Newcastle Jockey Club Stable Development (SSD-12982045)
Request for Further Information

ATTACHMENT A – REQUEST FOR INFORMATION

Emergency horse float turning paths – Drawings 160548-T03, T04 and T05 (Rev 4, 8.7.2022)

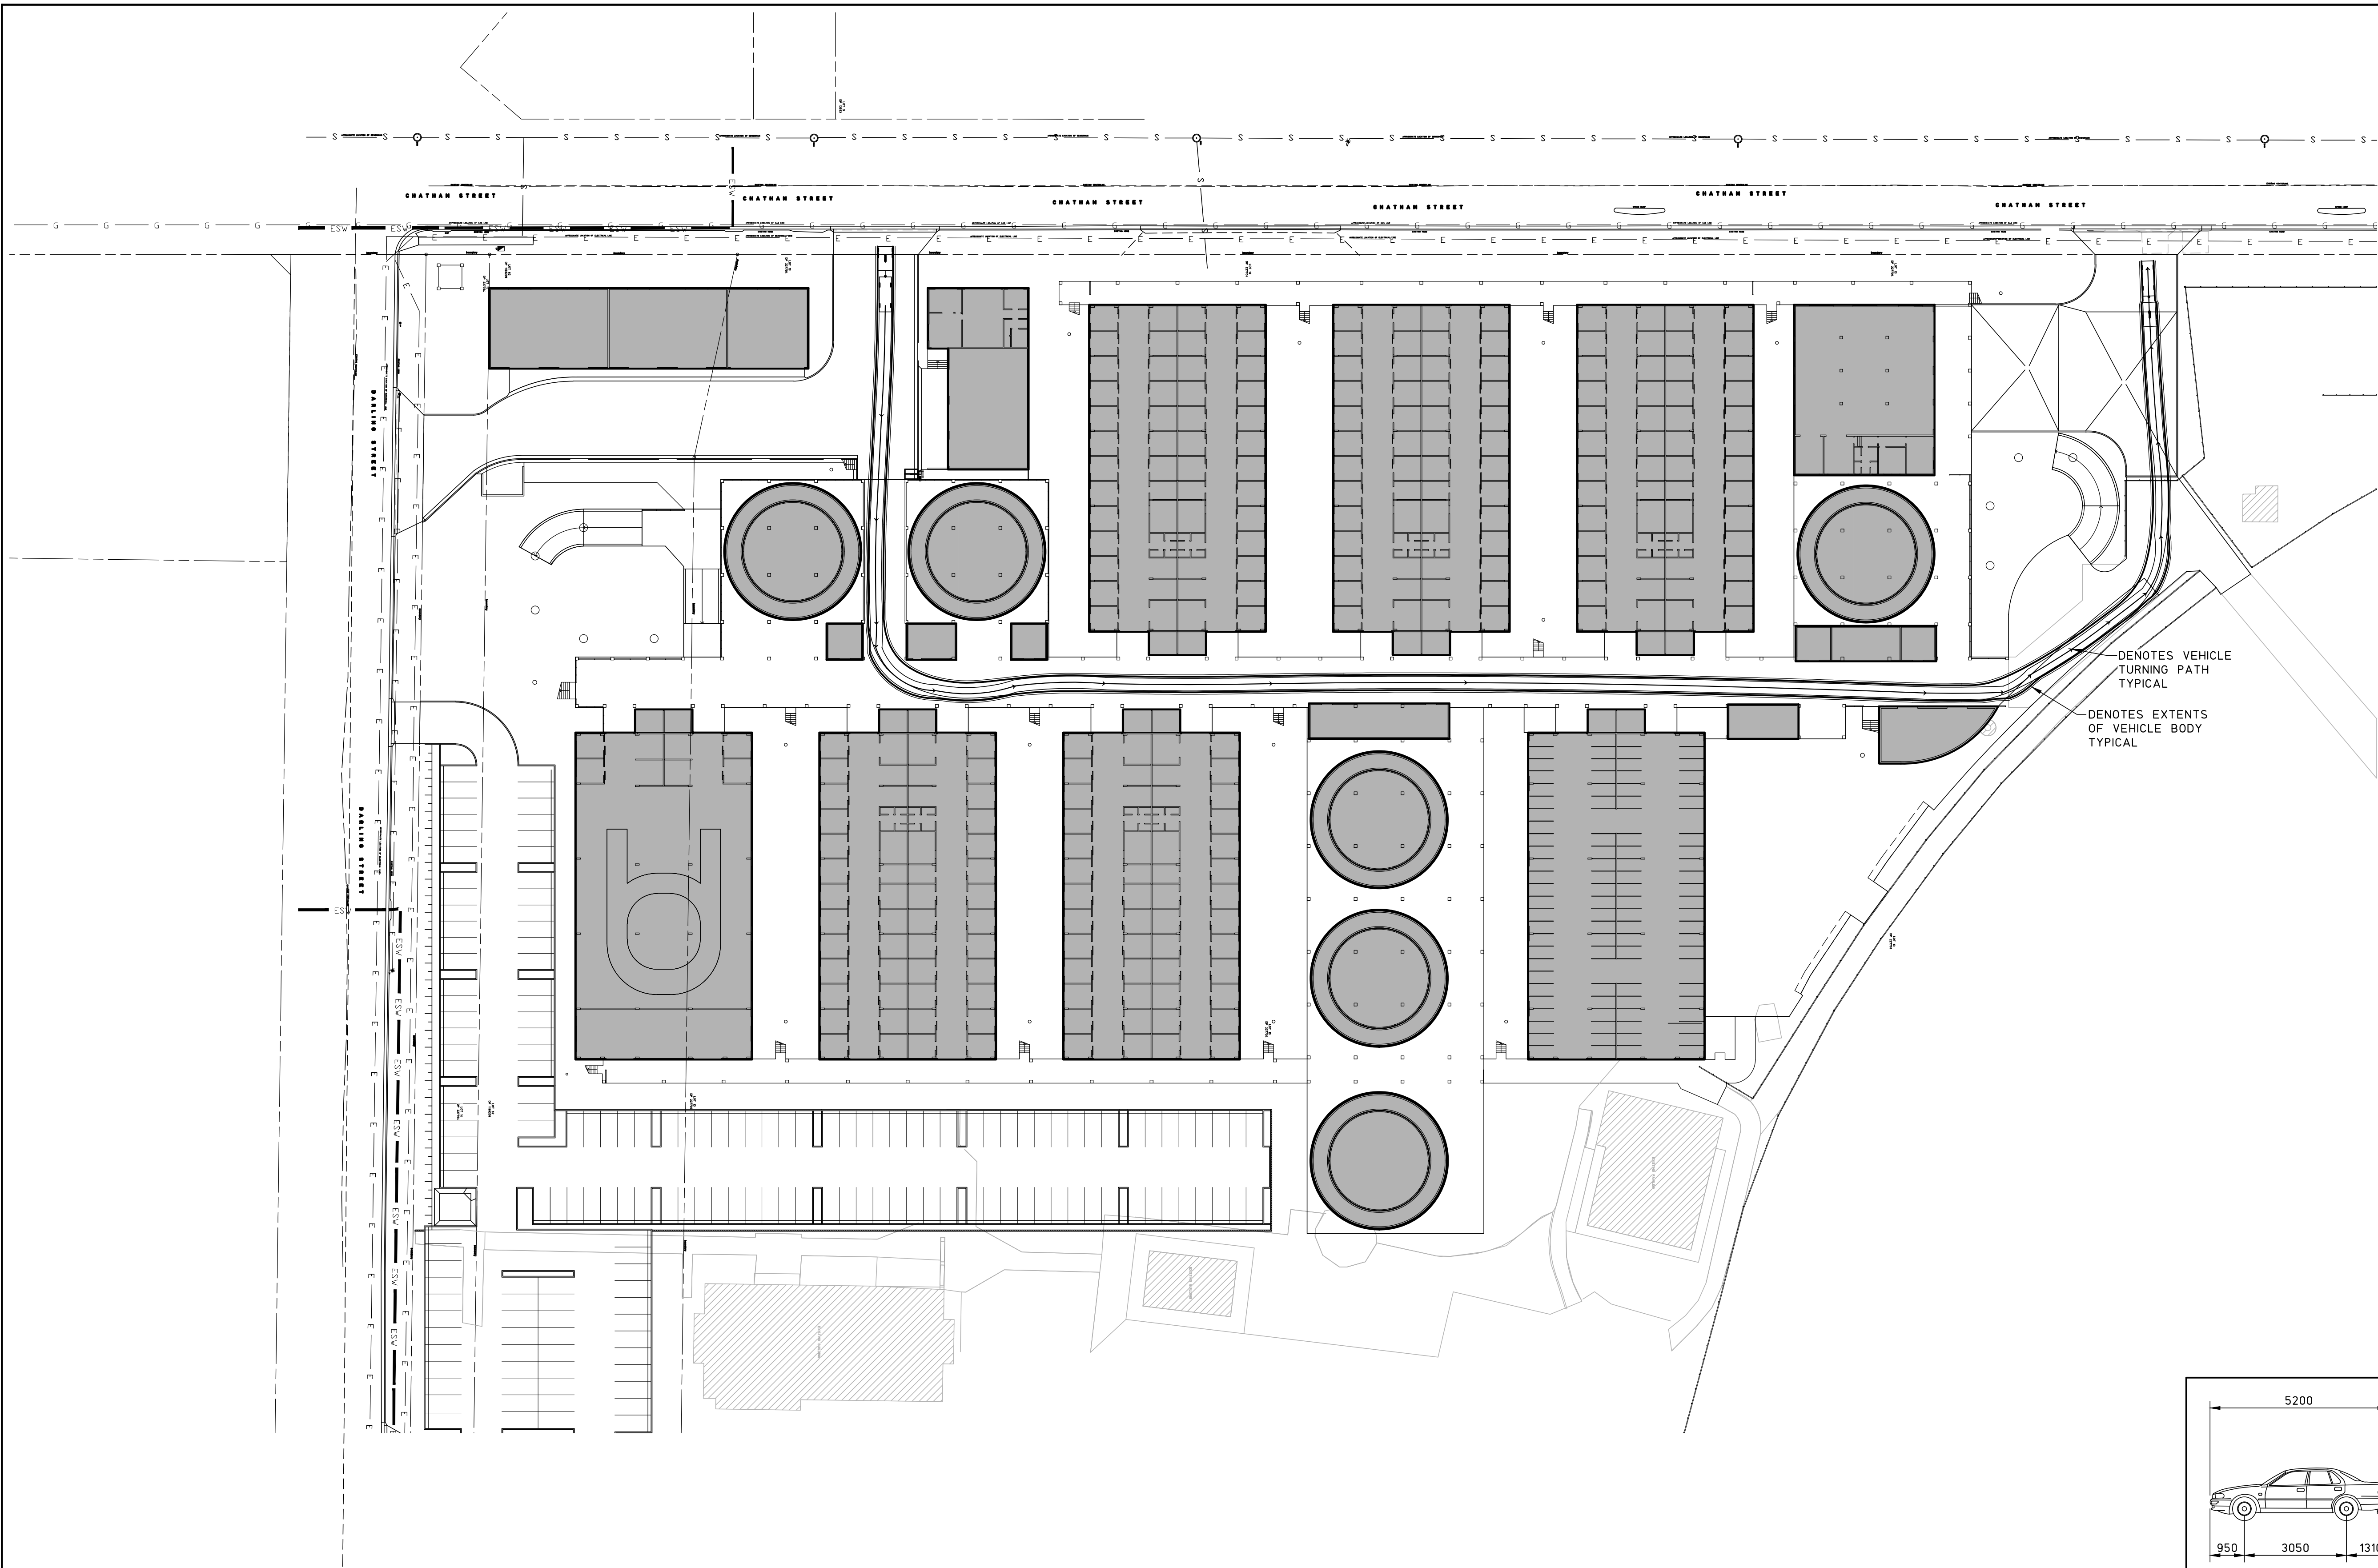
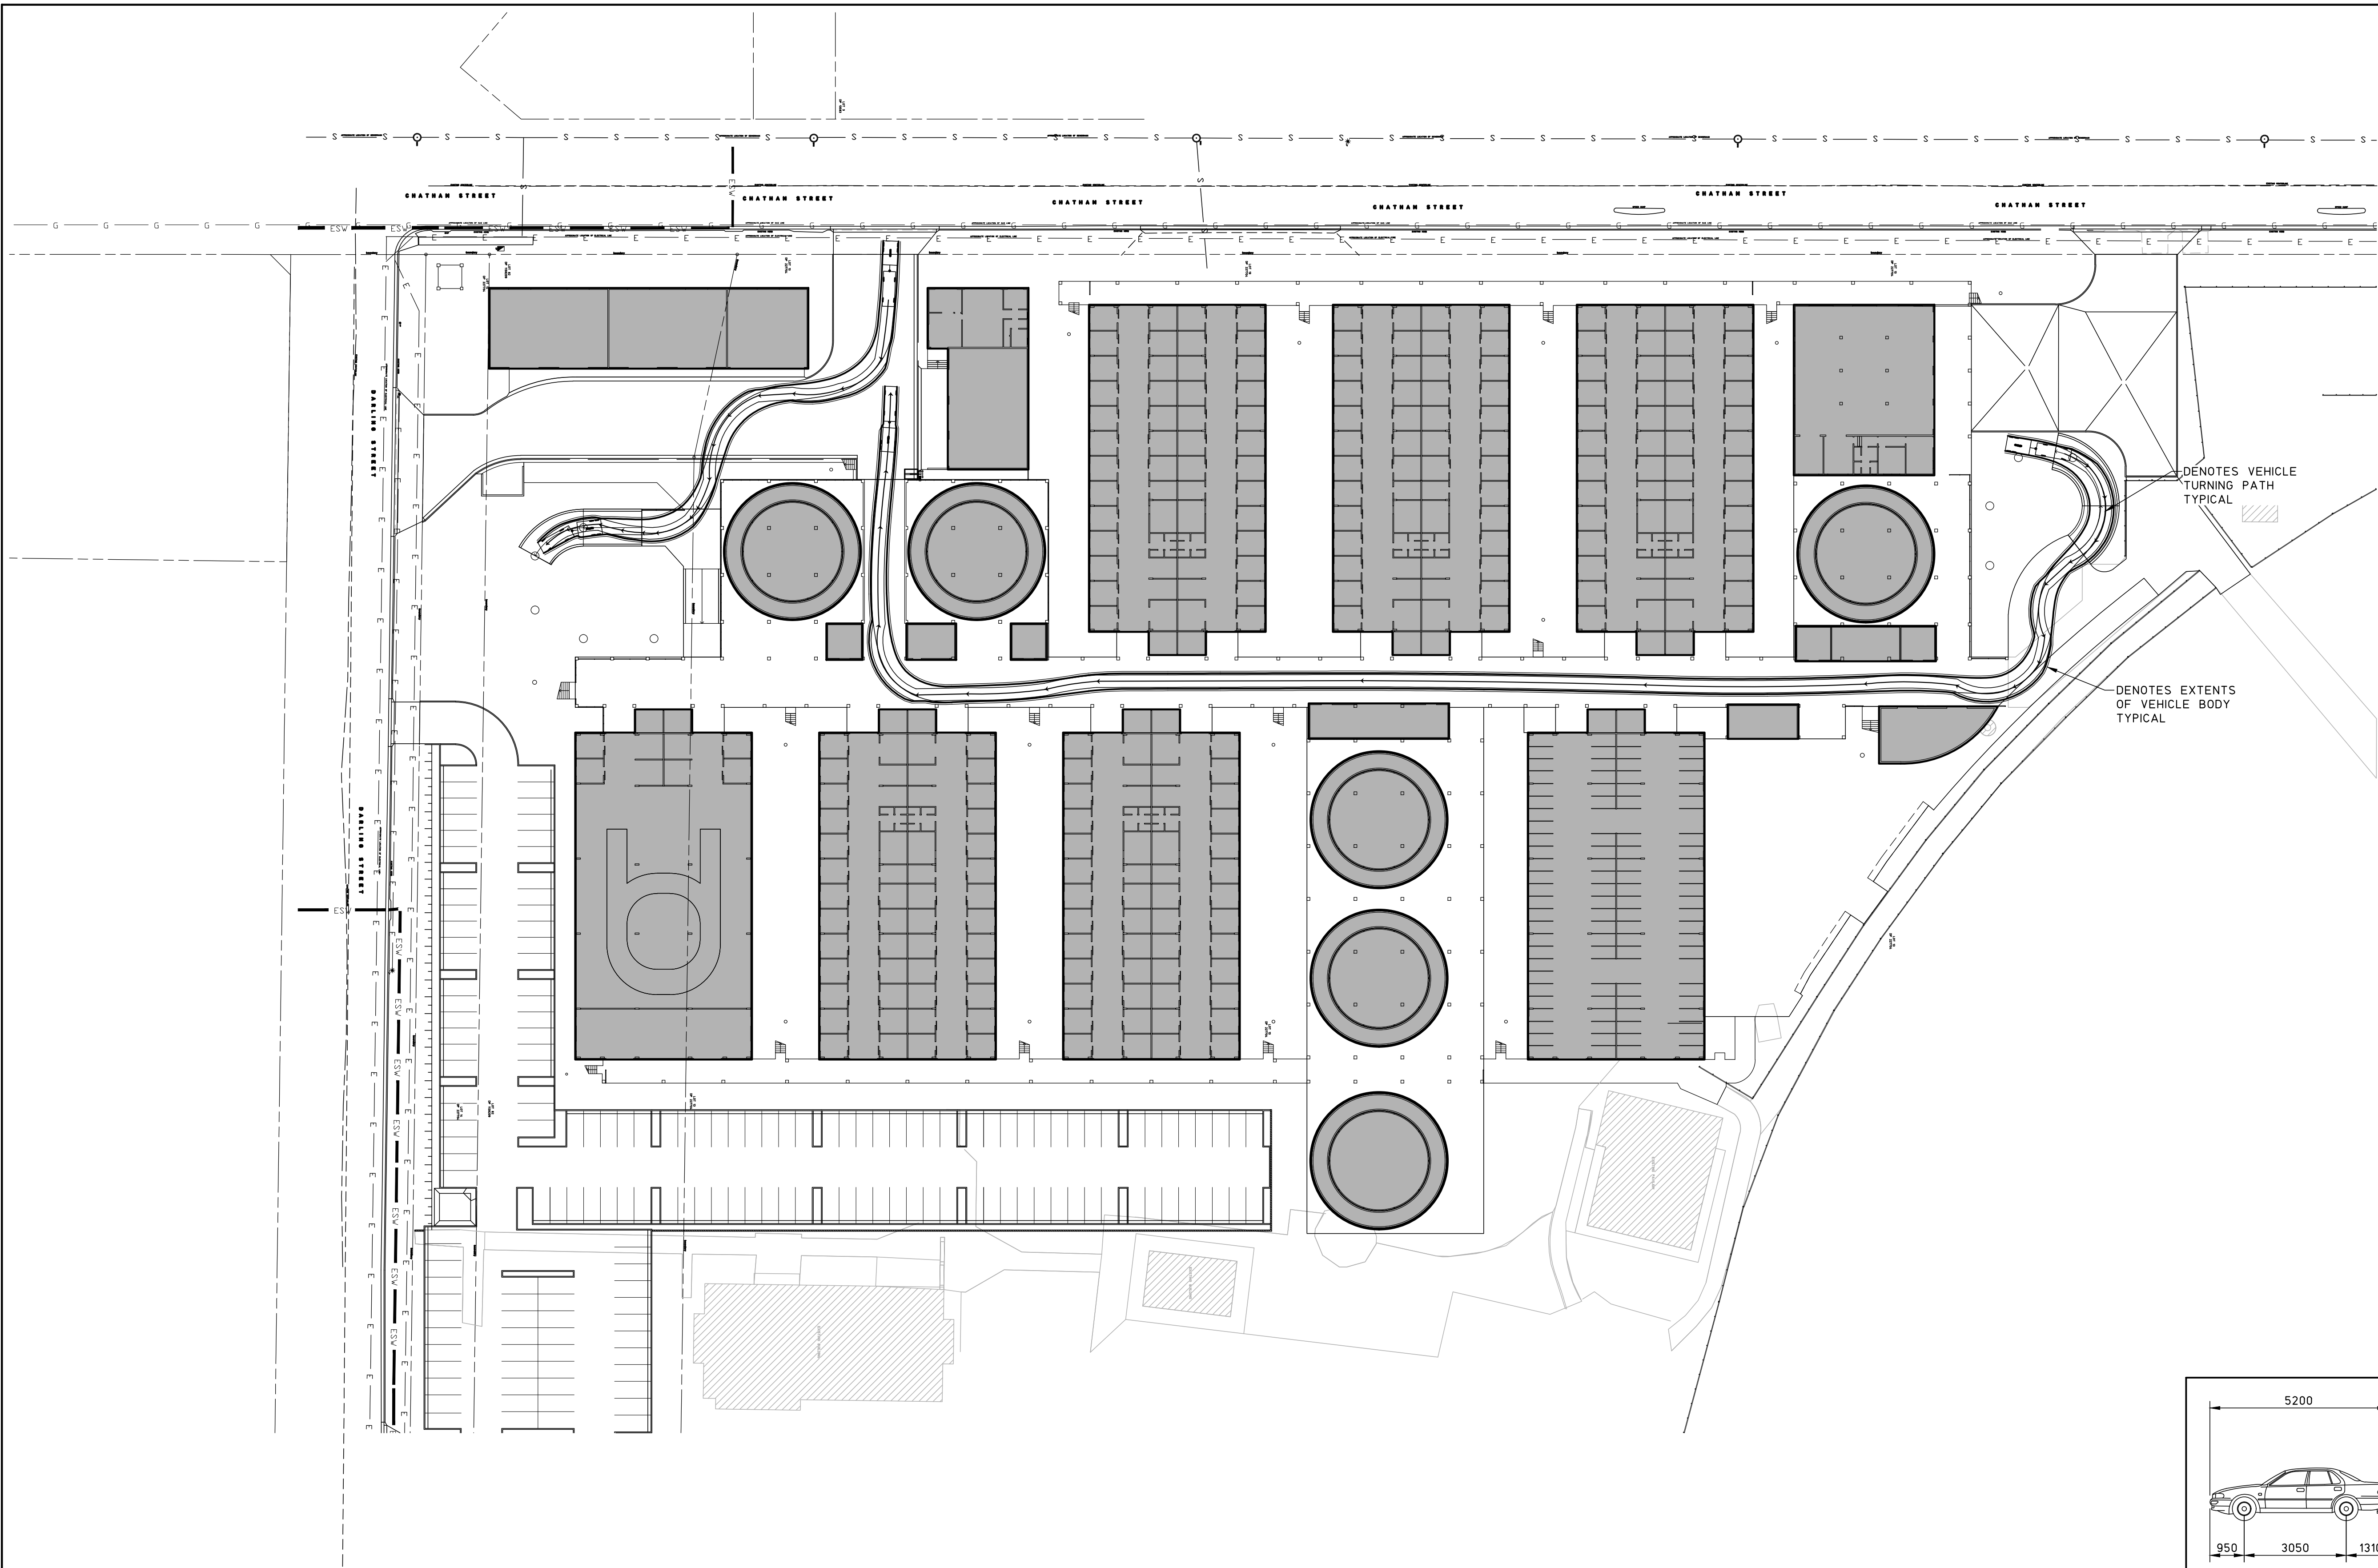
The Department requests that consideration be given to the submitted turning paths and the concerns raised by Council on their usability and potential safety issues. The Department requests that the vehicle movements on the upper and lower concourses be quantified to ascertain the potential conflicts with traffic in the Equine and Goods Drop Off Loading Zone.
